**WEST SUSSEX COUNTY COUNCIL
PLANNING SERVICES CONSULTATION**

SUBJECT: FG/198/16/PL

Demolition of existing house with erection of 2 storey building comprising of 8No. residential 2 bedroom flats & associated external works.

1, Sea Drive, Ferring, BN12 5HD

DWG NO: P/004

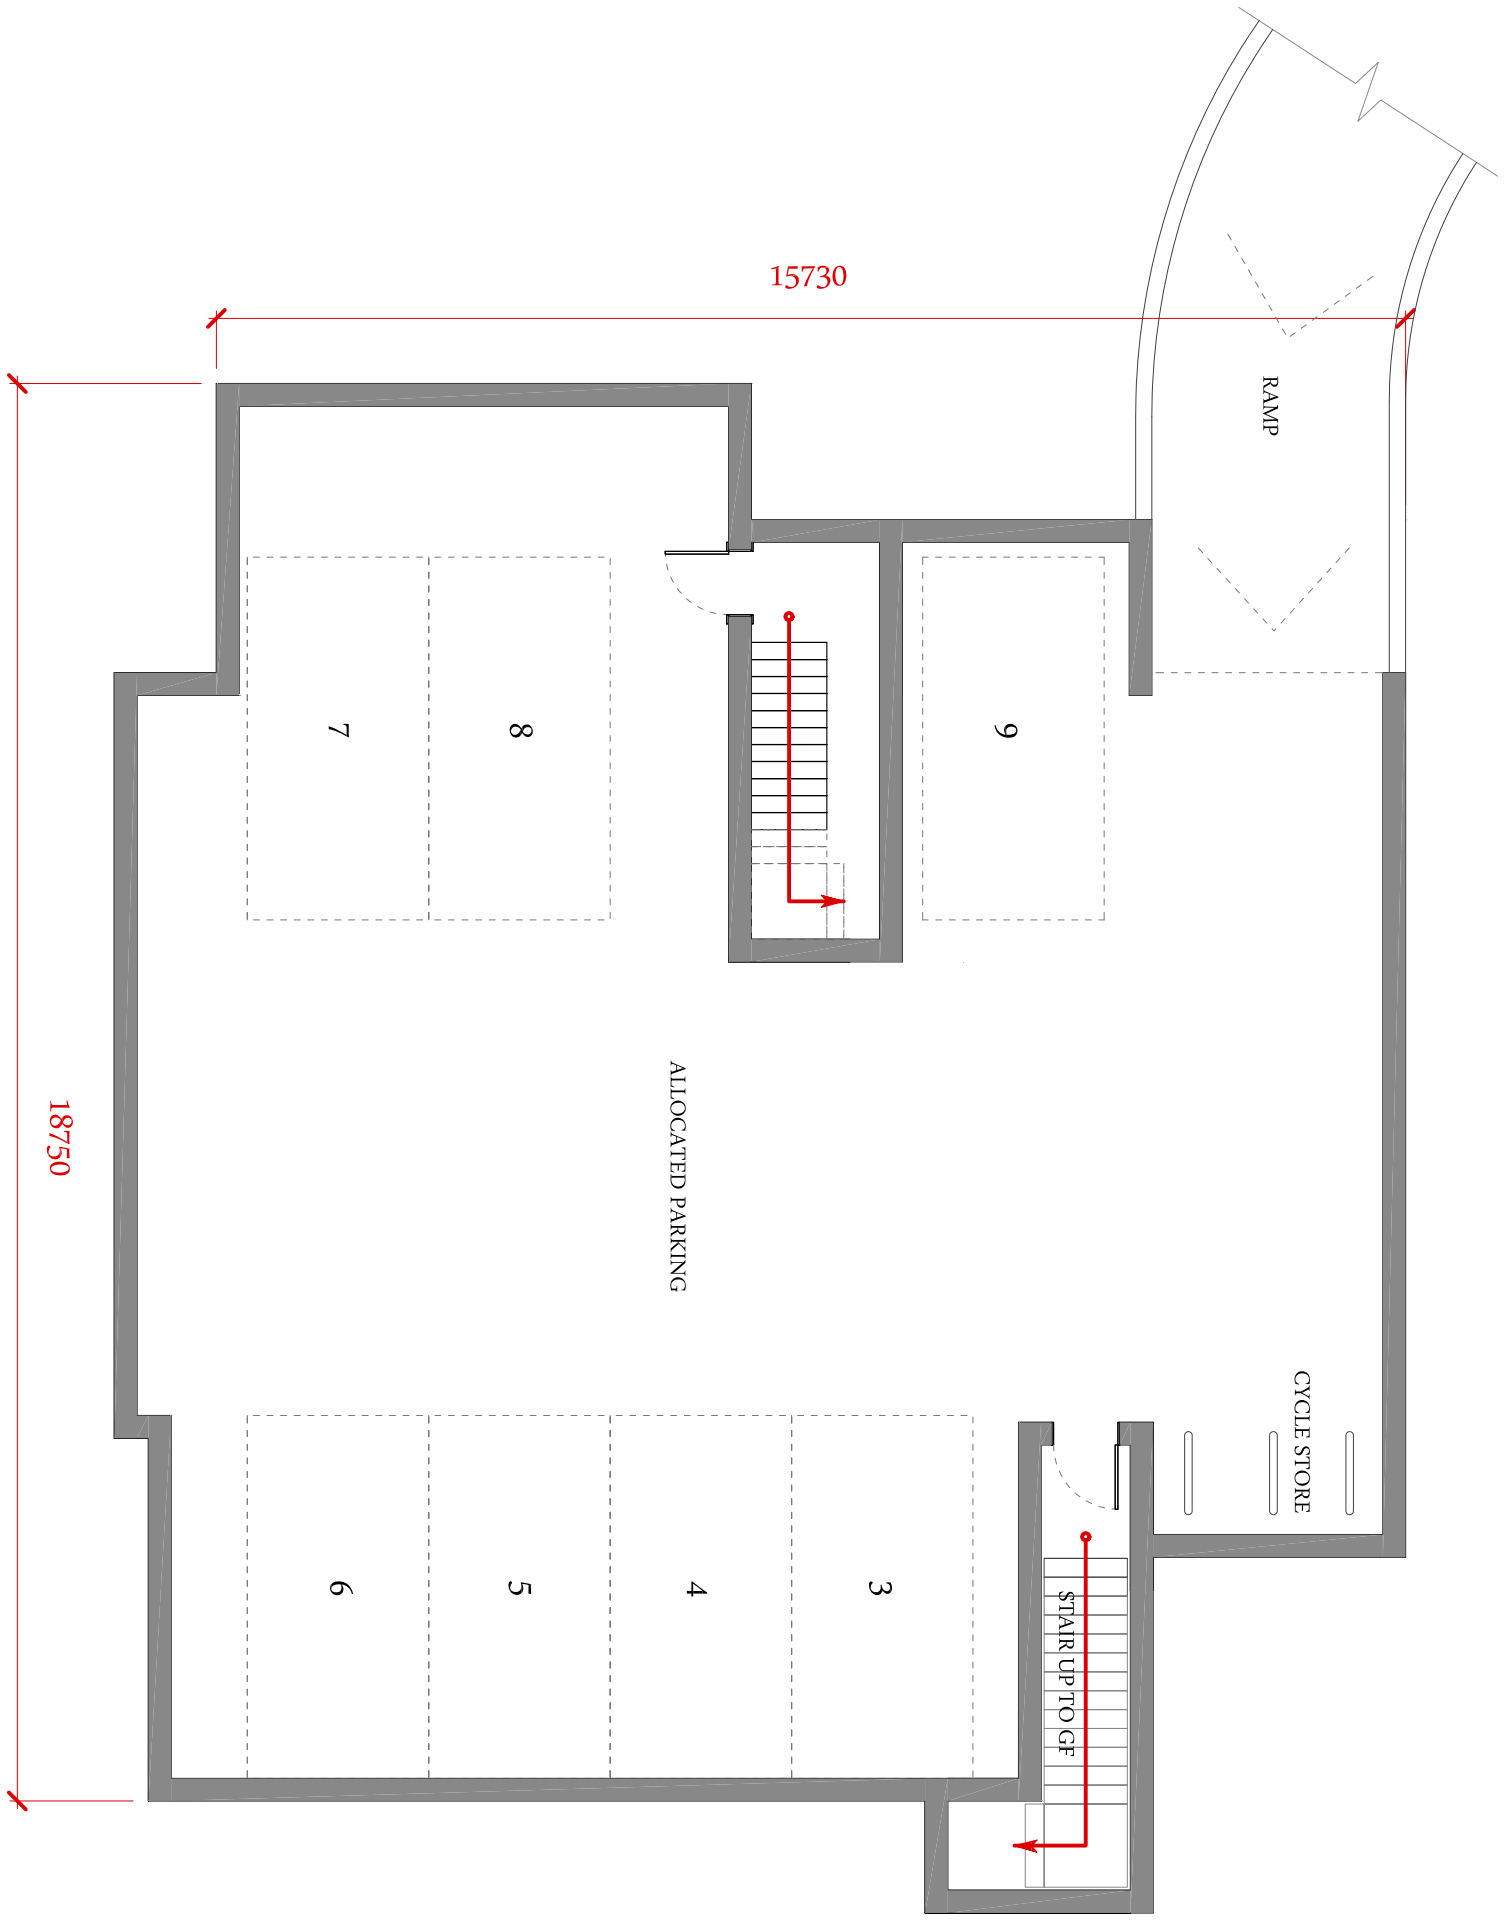
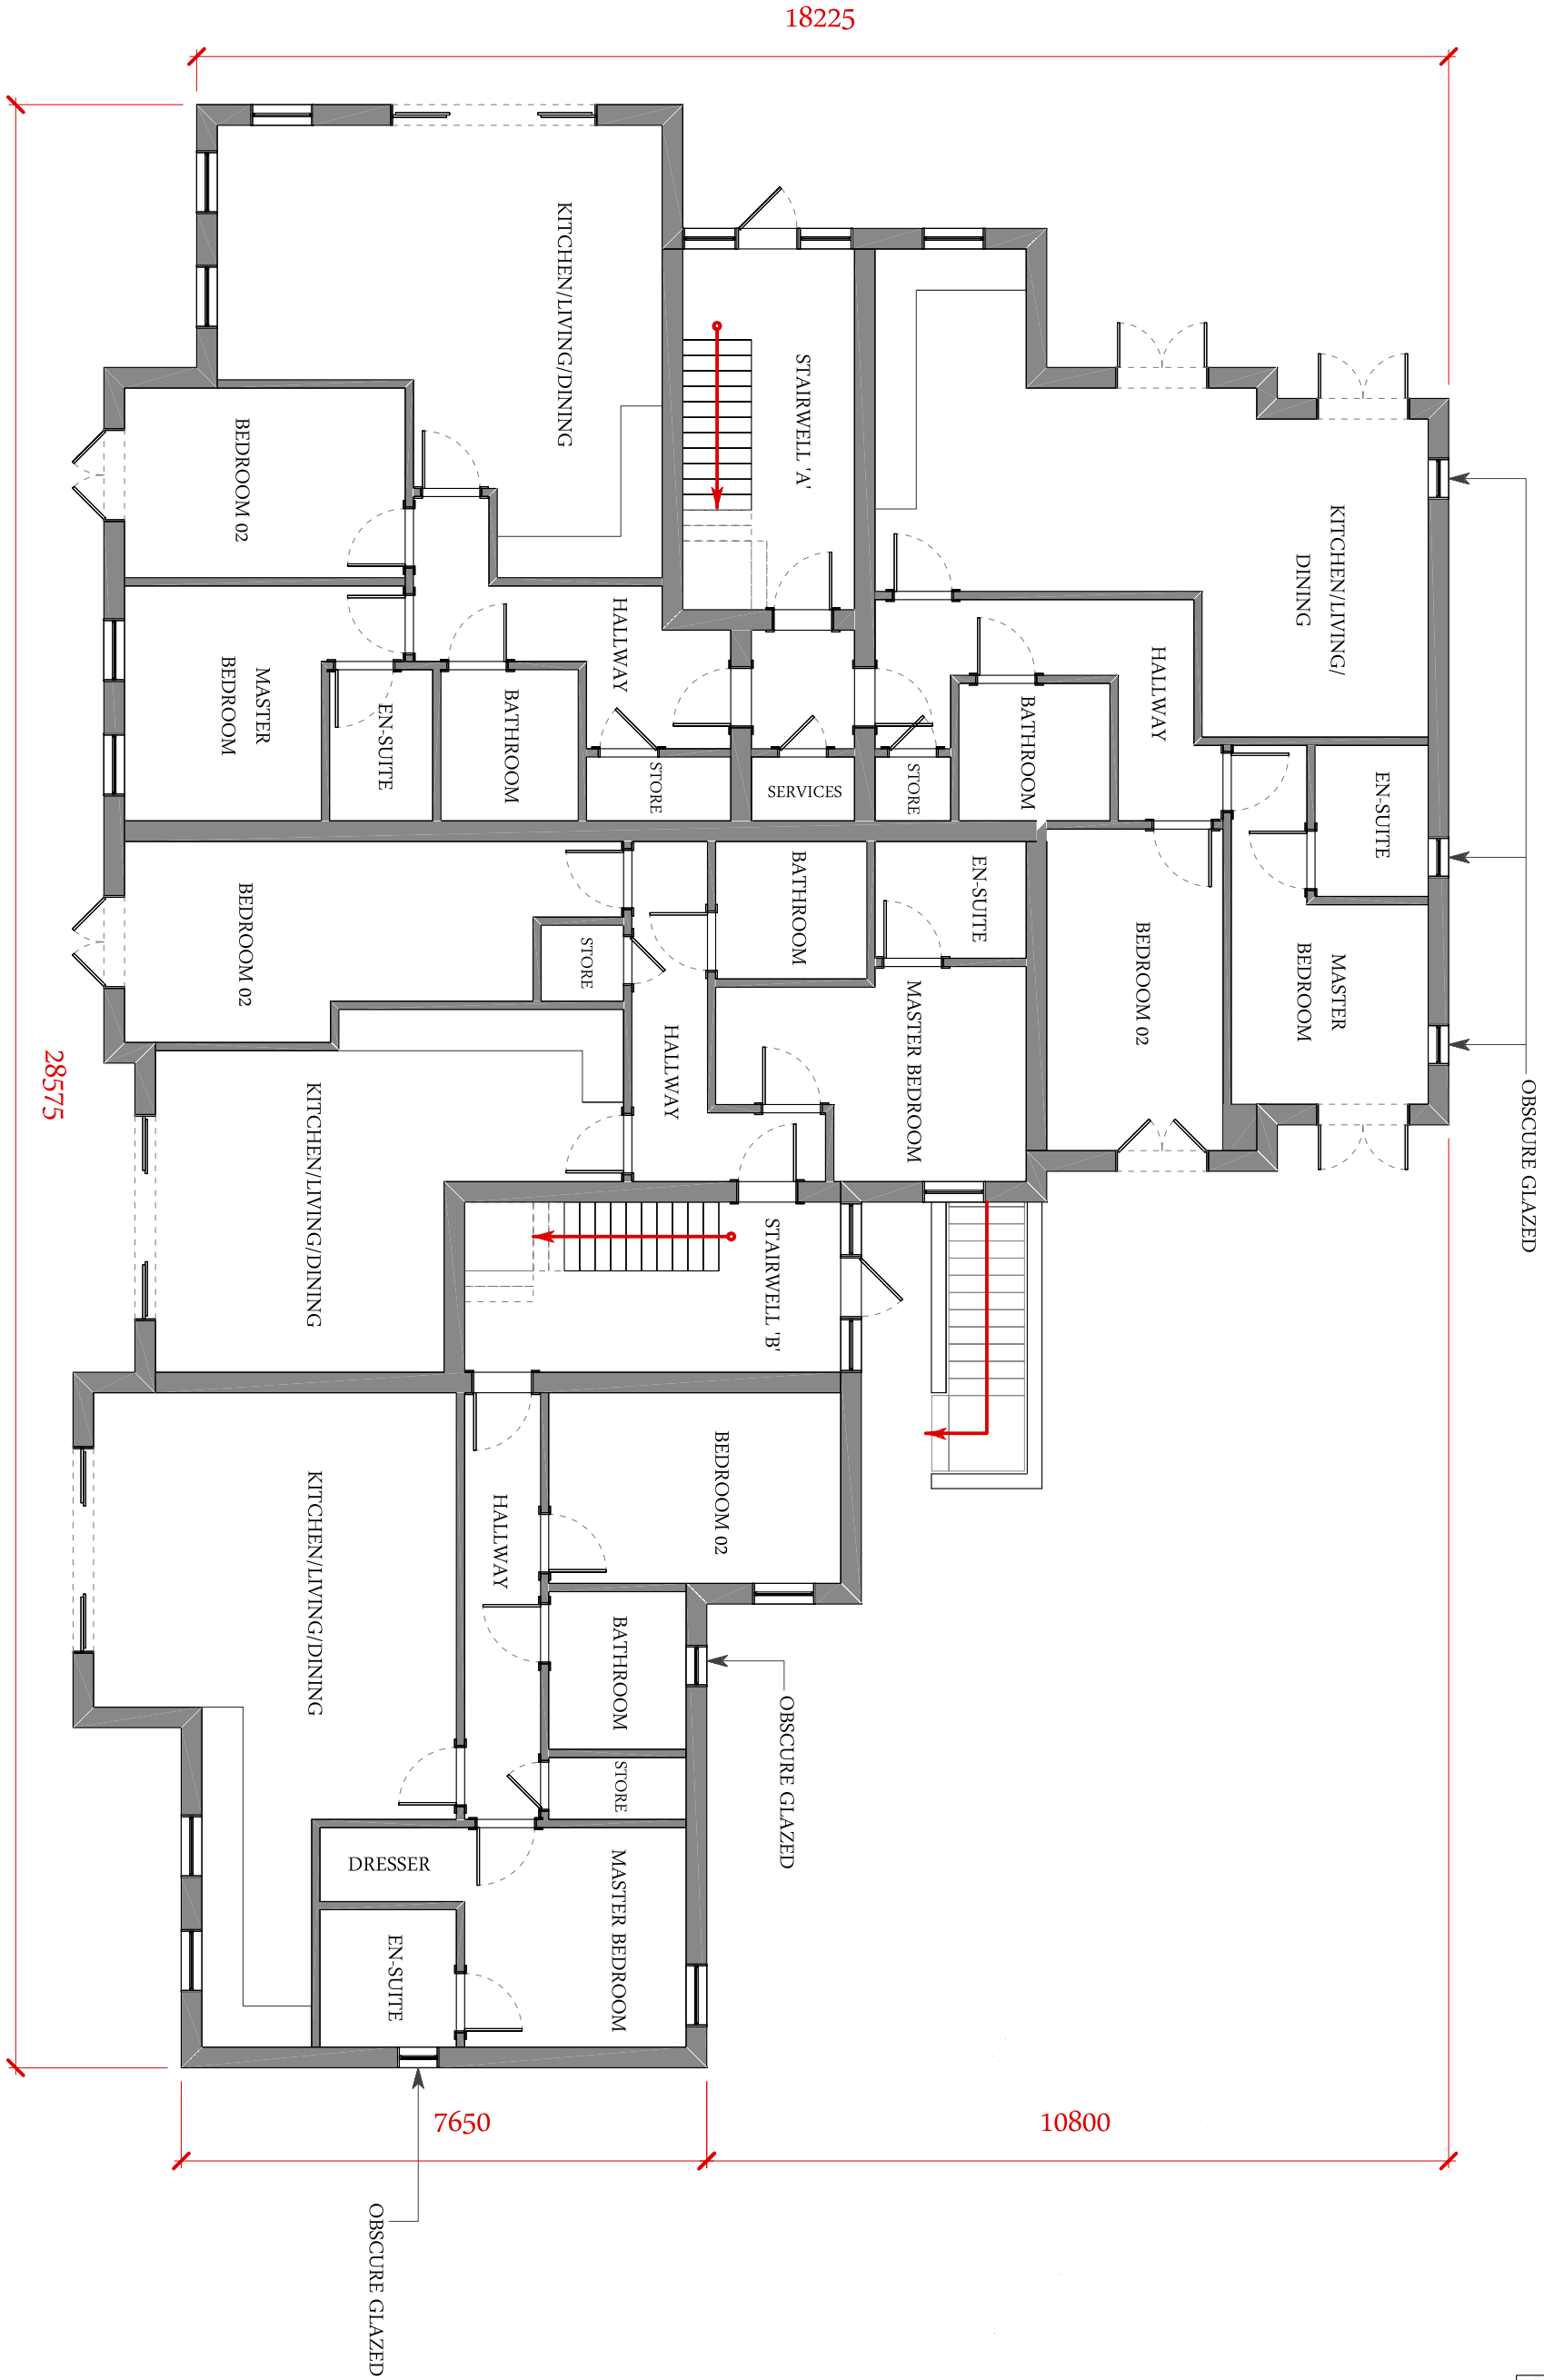
Substitute plan PL004 Rev L proposes to increase the parking provision by 3 spaces, increasing total capacity of the car park to 10 spaces. The Applicant has subsequently submitted plan PL007 Rev A which provides a vehicular tracking assessment of the revised layout.

The landing area at the bottom of the ramp has been extended to accommodate a parking space. This will discourage parking outside of the marked bays at this location. In turn, this will protect the space required to undertake a turning manoeuvre, should a vehicle enter the car park when all spaces are already occupied. The LHA have tracked this manoeuvre and confirm that an unimpeded 3-point turn can be undertaken.
